INSPECTION REPORT

DATE OF INSPECTION: 3/16/2020
COMPANY NAME: Twilight Homes
PROJECT NAME: Sunset Villa
LOCATION: 500 Twilight Vista Lane, Albuquerque, New Mexico, 87105
TRACKING NO: NMR1001H2
COMPLIANCE EVALUATION: Unsatisfactory
TYPE OF INSPECTION: 14Day
START TIME: 11:30 AM
END TIME: 11:45 AM
INSPECTOR'S NAME: Kasey Anderson
INSPECTOR'S TITLE: Environmental Inspector
INSPECTOR'S QUALIFICATIONS: Storm Water Qualified Person
INSPECTOR'S CONTACT: 505-280-7766
PHASE OF CONSTRUCTION:
☐ Clear and Grub
 ☒ Excavation
 ☒ Building (vertical)
 ☒ Rough Grading
 ☒ Infrastructure
 ☒ Final Grading
 ☐ Final Stabilization

Erosion Sediment Control Plan

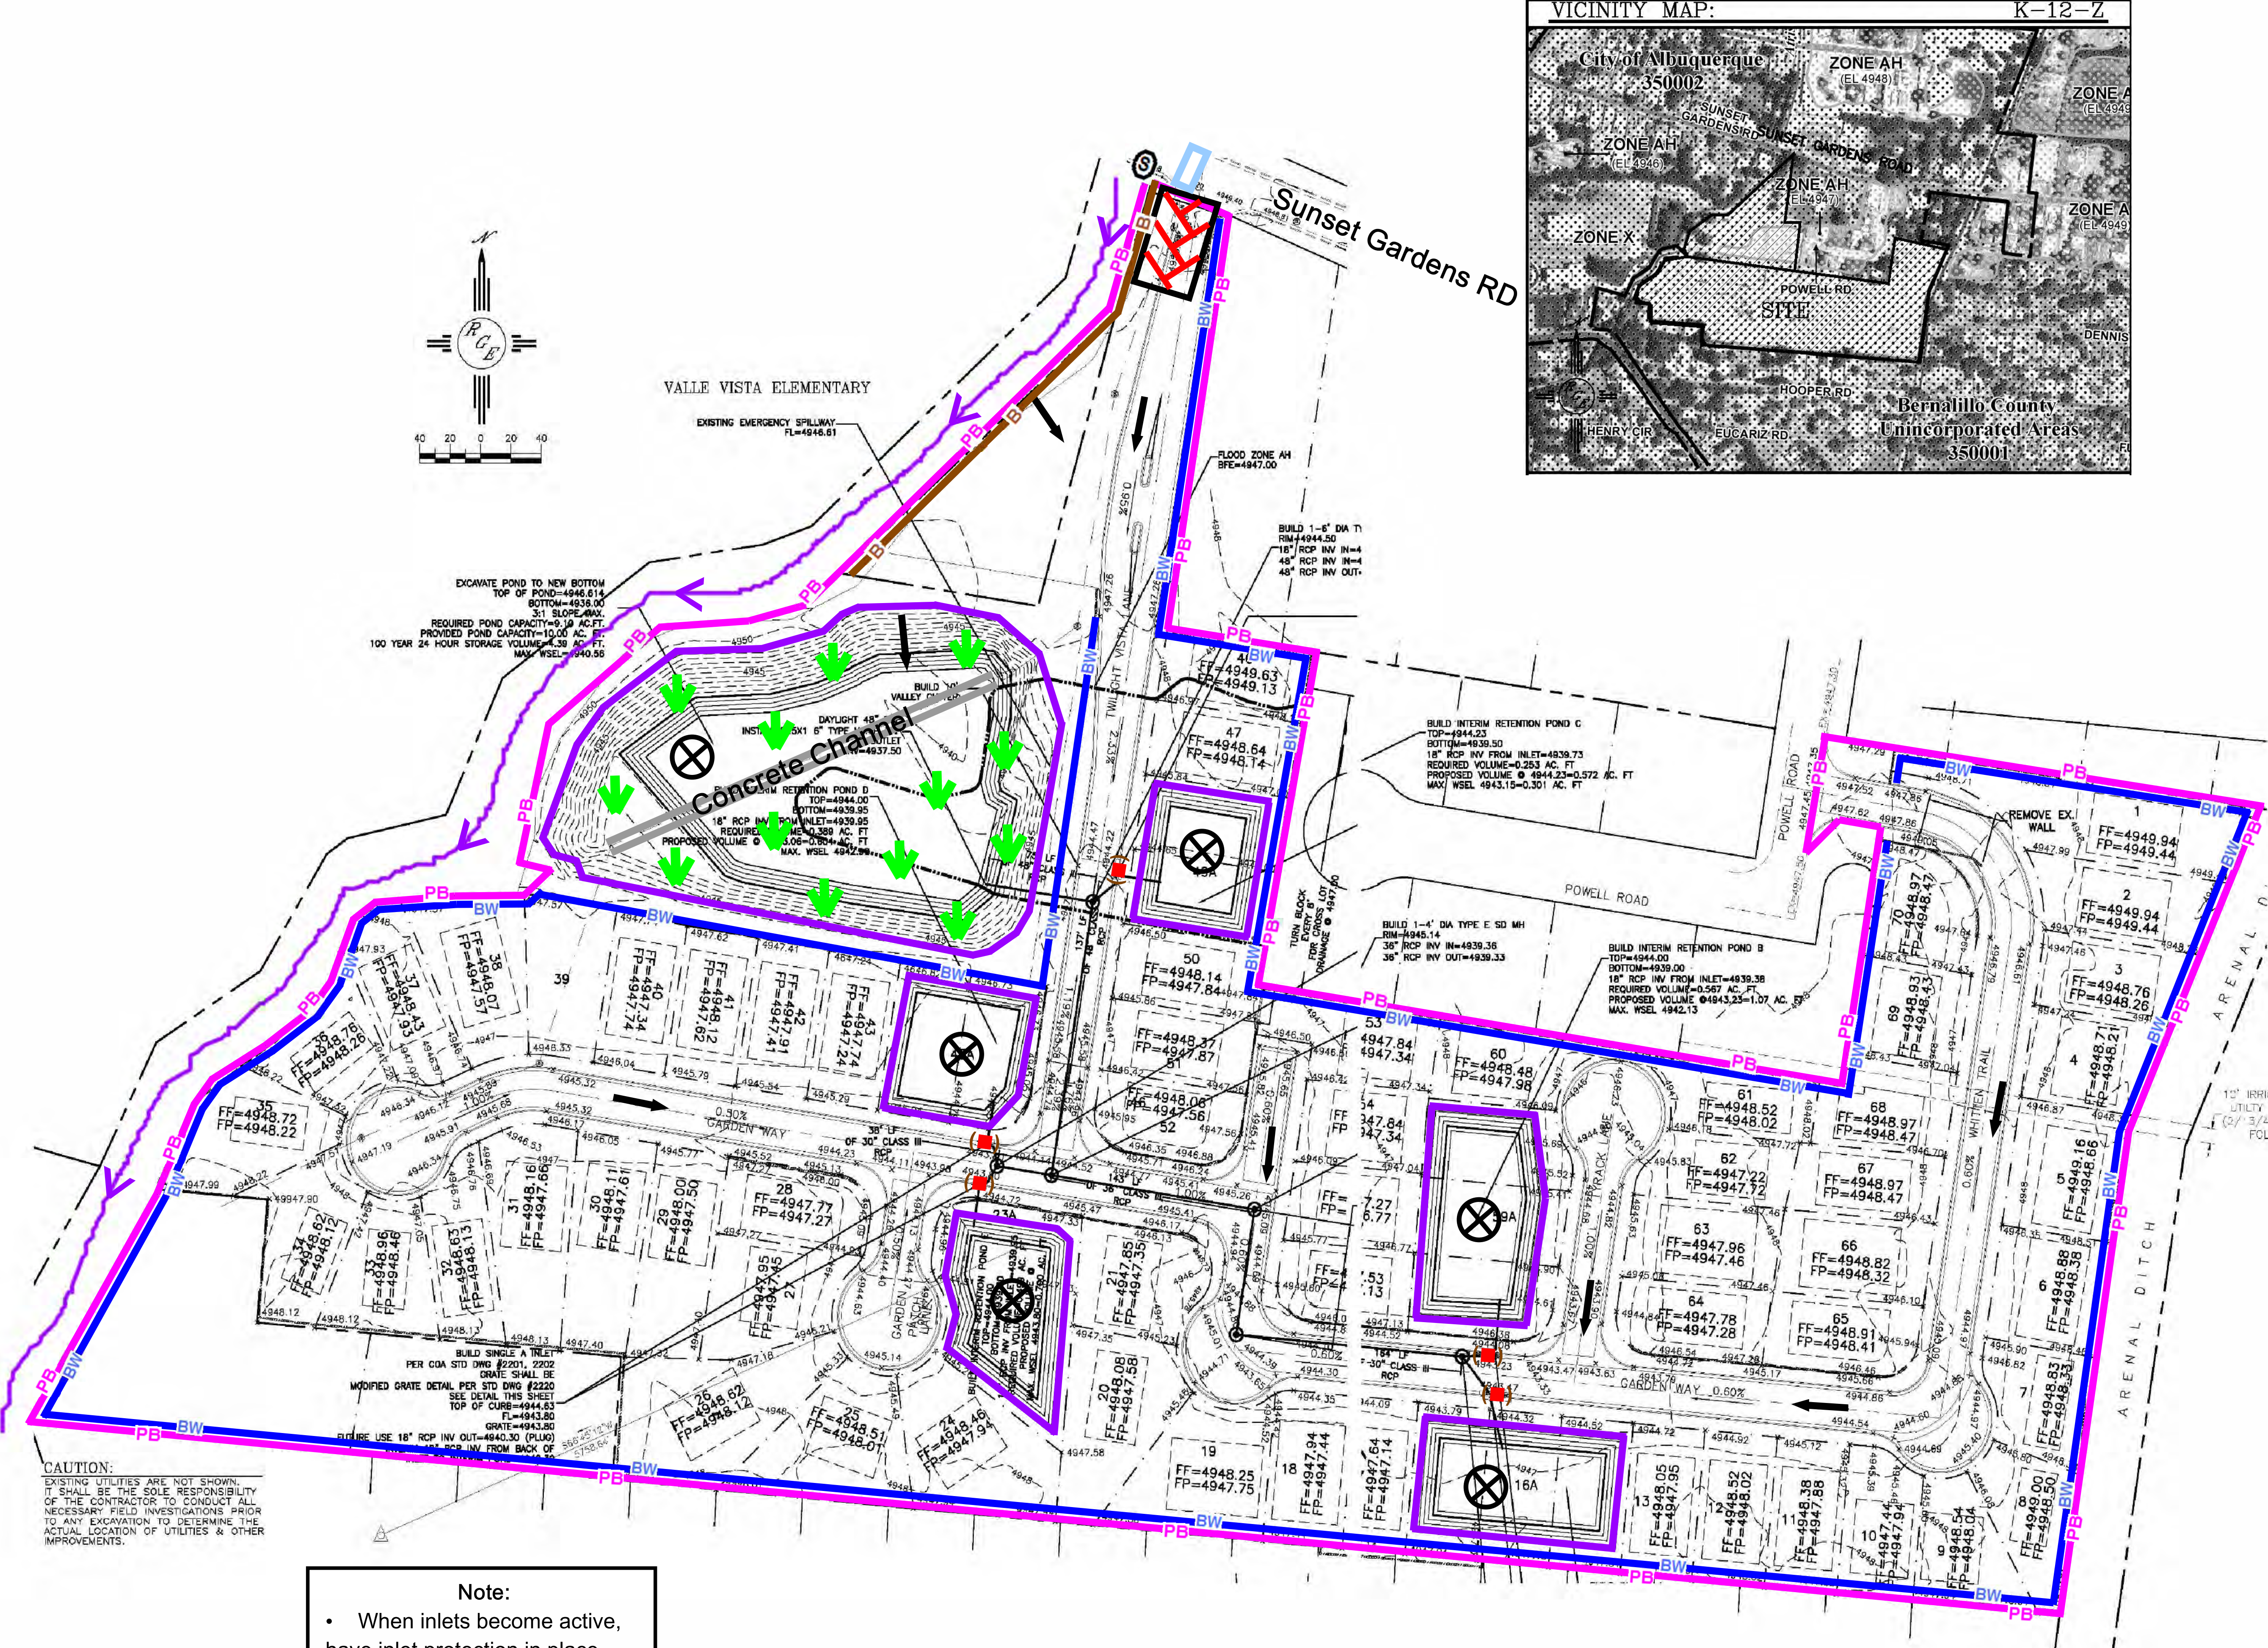
| # | S&E/P2 CONTROLS | MAINTENANCE | CORRECTIVE ACTION | LOCATION | QUANTITY | UNIT | PHOTO |
|---|------------------------|-------------|-------------------|--|----------|------|---------------------|
| 1 | Inlet Protection | None | Initial Install | Add inlet protections to inlets on Twilight Vista and Garden Way | 5 | EA | Yes |
| 2 | Wattles/Socks/Log Roll | Update | None | 1739 Garden Way; remove or add wattle in front of dirt pile. | 25 | LF | |
| 3 | Silt Fence | None | Replace | Replace 20ft section of silt fence at 605 Garden Patch | 20 | LF | |
| 4 | Sanilets | Anchor | None | Anchor portable toilet on Whitten Tr | 1 | EA | |

| # | INSPECTION ITEM | INSPECTOR'S OBSERVATION | ACTION REQUIRED? | NOTES |
|----|---|---|---|--|
| 4 | Are natural resource areas (e.g. streams, wetlands, mature trees, etc.) protected with barriers or similar BMPs? | <input type="radio"/> Yes <input checked="" type="radio"/> No <input type="radio"/> N/A | <input checked="" type="radio"/> Yes <input type="radio"/> No | Add inlet protections to inlets on Twilight Vista and Garden Way. |
| 14 | Is the project being operated in compliance with the SWPPP and with permit conditions at this time? | <input type="radio"/> Yes <input checked="" type="radio"/> No <input type="radio"/> N/A | <input checked="" type="radio"/> Yes <input type="radio"/> No | Storm drain inlets need protection, especially since there are a lot of dirt curb ramps into Twilight lots. |
